Ribble Valley Borough Council  
Housing & Development Control

Application no: **3/2023/1051**

Address: **24 Waddow Grove Waddington BB7 3JL**

Proposal: **Two storey extension to side and rear to include two rear dormers following demolition of existing extension, rooflights to side elevation and internal reconfiguration to residential property.**

name
Proposed Site and Roof Plan

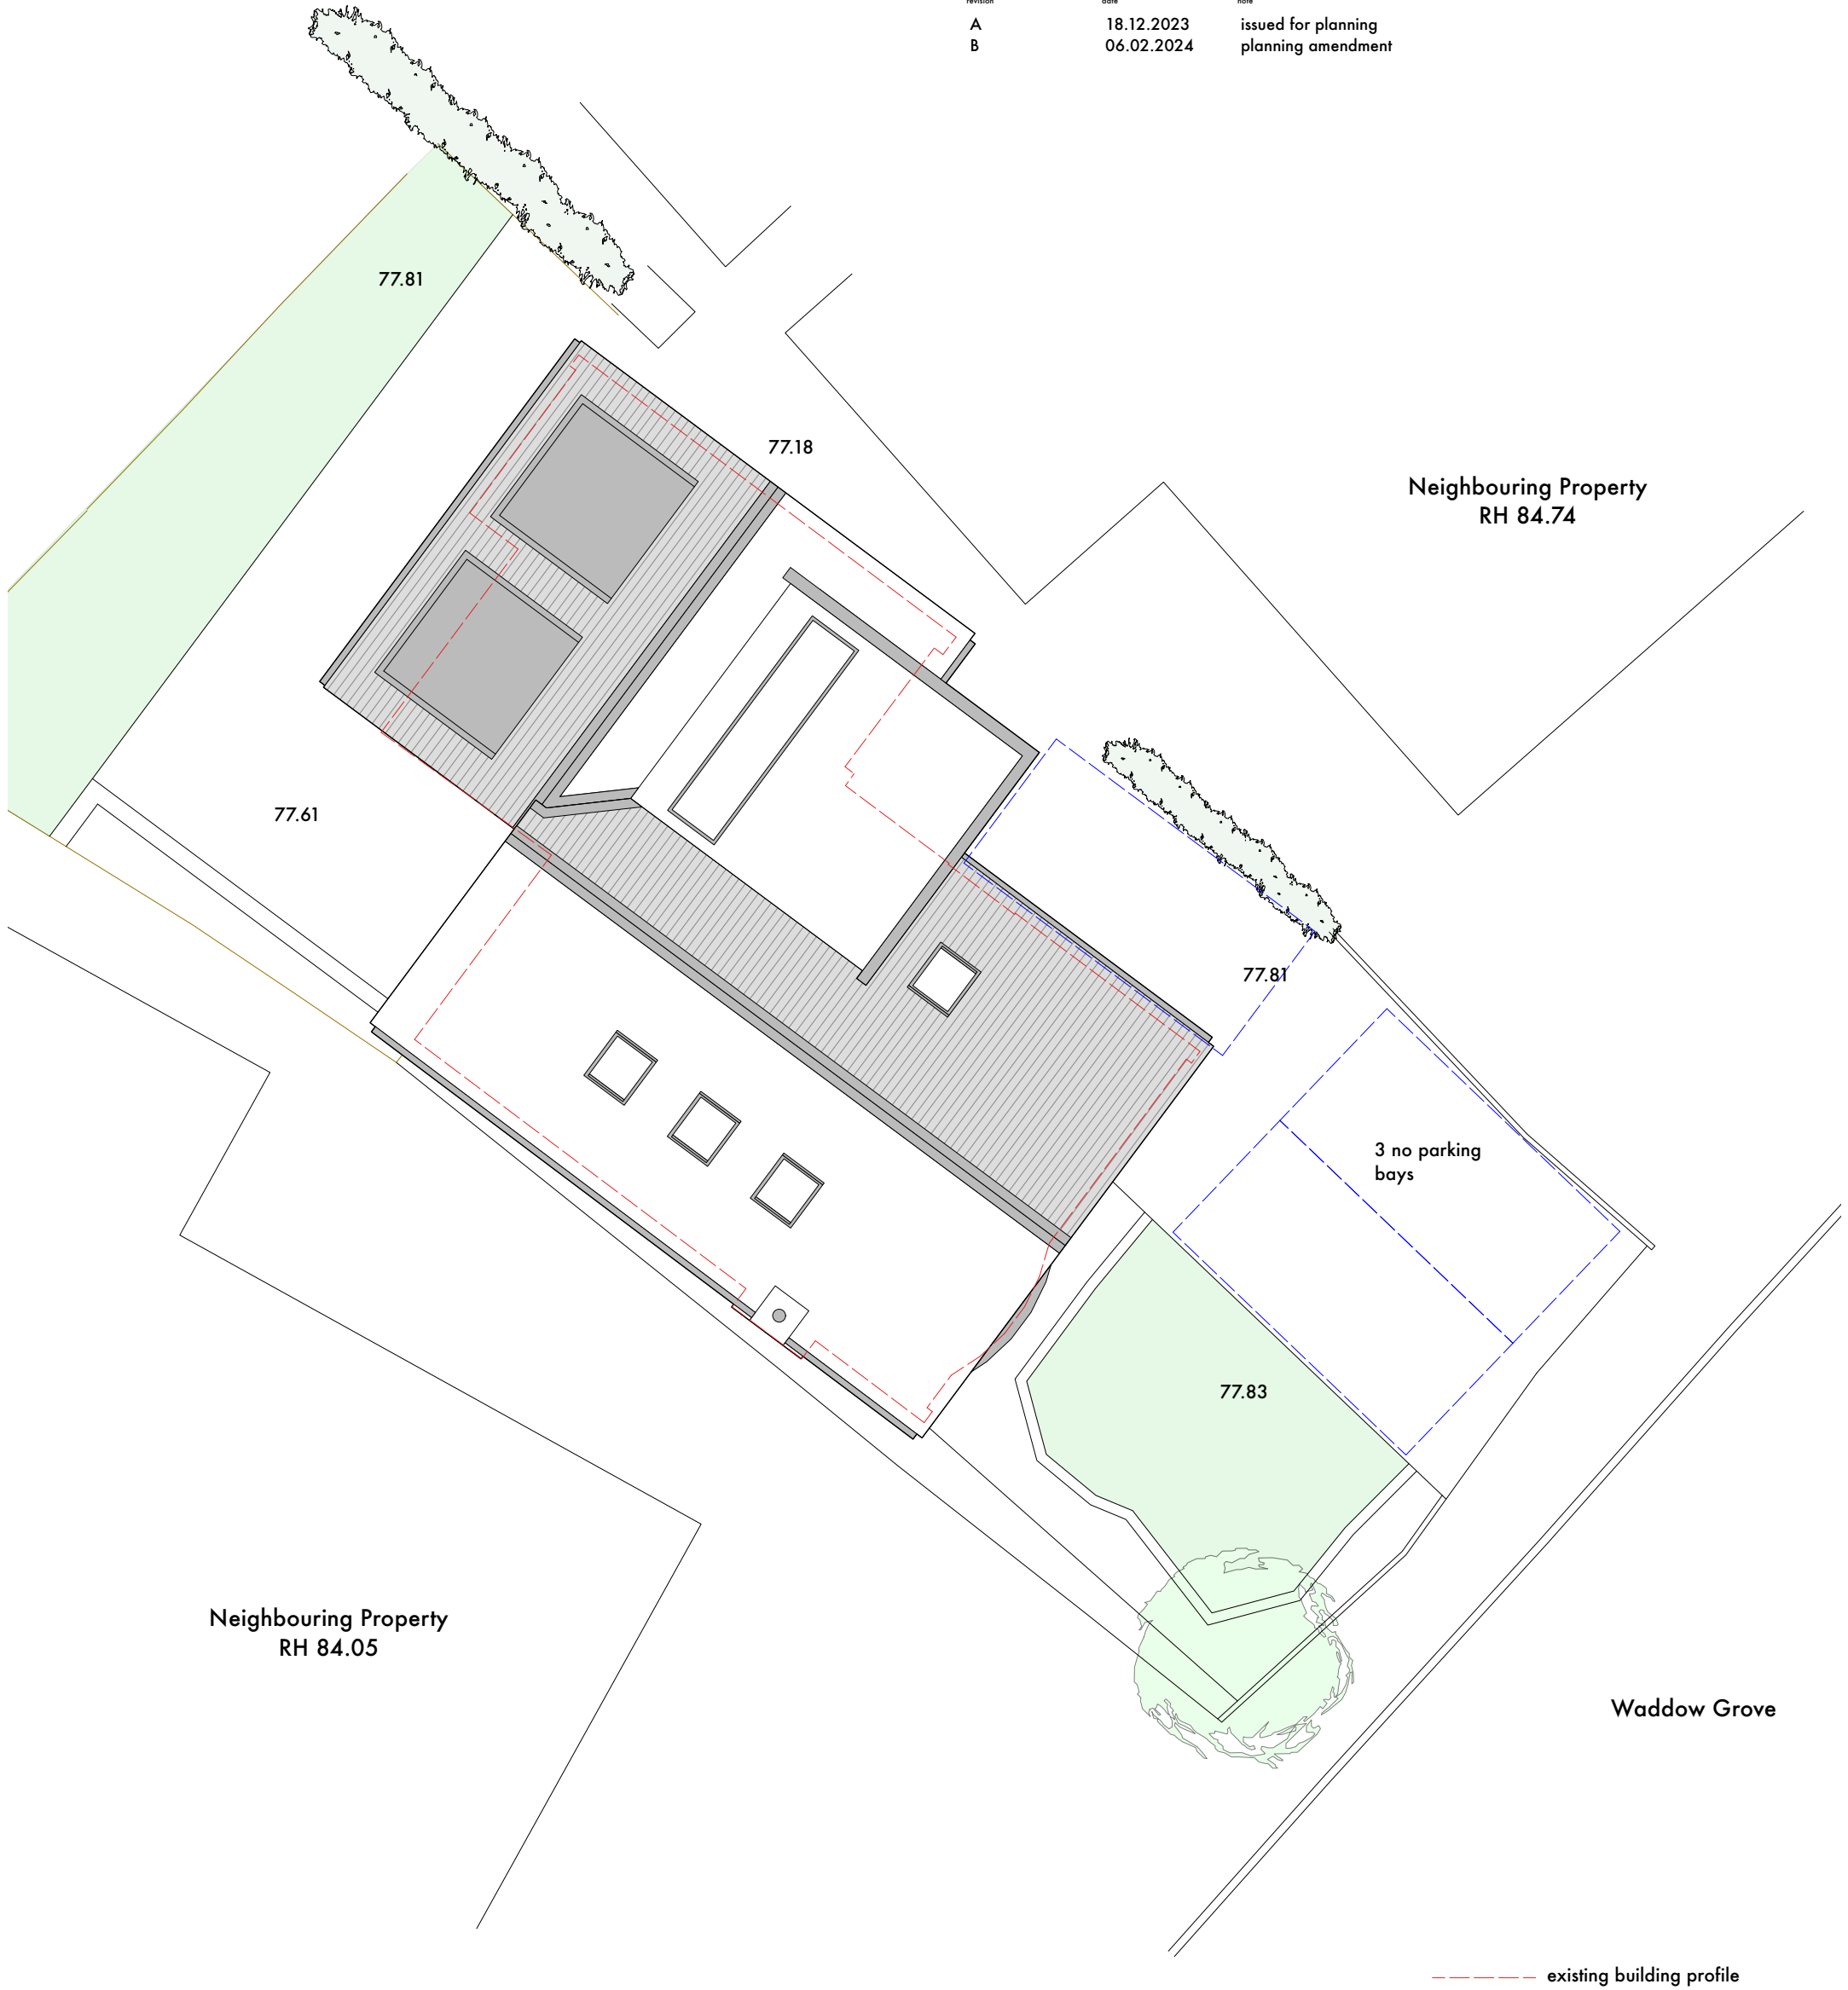
The LHA have reviewed Stanton Andrews drawing number PL01 Rev B titled "Proposed Site and Roof Plan" and are aware that the dwelling can now provide 3 car parking spaces for the proposed 4 bed dwelling. The parking arrangements now complies with the LHAs parking guidance as defined within the Joint Lancashire Structure Plan

To provide the additional car parking space, the existing dropped vehicle crossing will need amending to allow access to the additional parking space. This will need to be carried out under an agreement (Section 171) with Lancashire County Council, as the highway authority. Please see the informative below for more information.

The LHA also inform the Agent/ Applicant that the gully provided adjacent to the existing site access may need to be relocated as part of the extension to the dropped crossing. This requirement will be assessed as part of the Section 171 agreement.

1.No building or use hereby permitted shall be occupied or use commenced until dropped kerbs have been installed at the carriageway edge and a vehicle cross-over constructed across the footway fronting the site in accordance with the approved plans and Lancashire County Council's Specification for Construction of Estate Roads, to be retained in that form thereafter for the lifetime of the development.

2.The proposed development should not be brought into use unless and until the parking area shown on the approved plans has been constructed, laid out and surfaced in bound porous materials. The parking area shall thereafter always remain available for the parking of domestic vehicles associated with the dwelling.

3.The surface water from the approved driveway/hardstanding shall be collected within the site and drained to a suitable internal outfall.
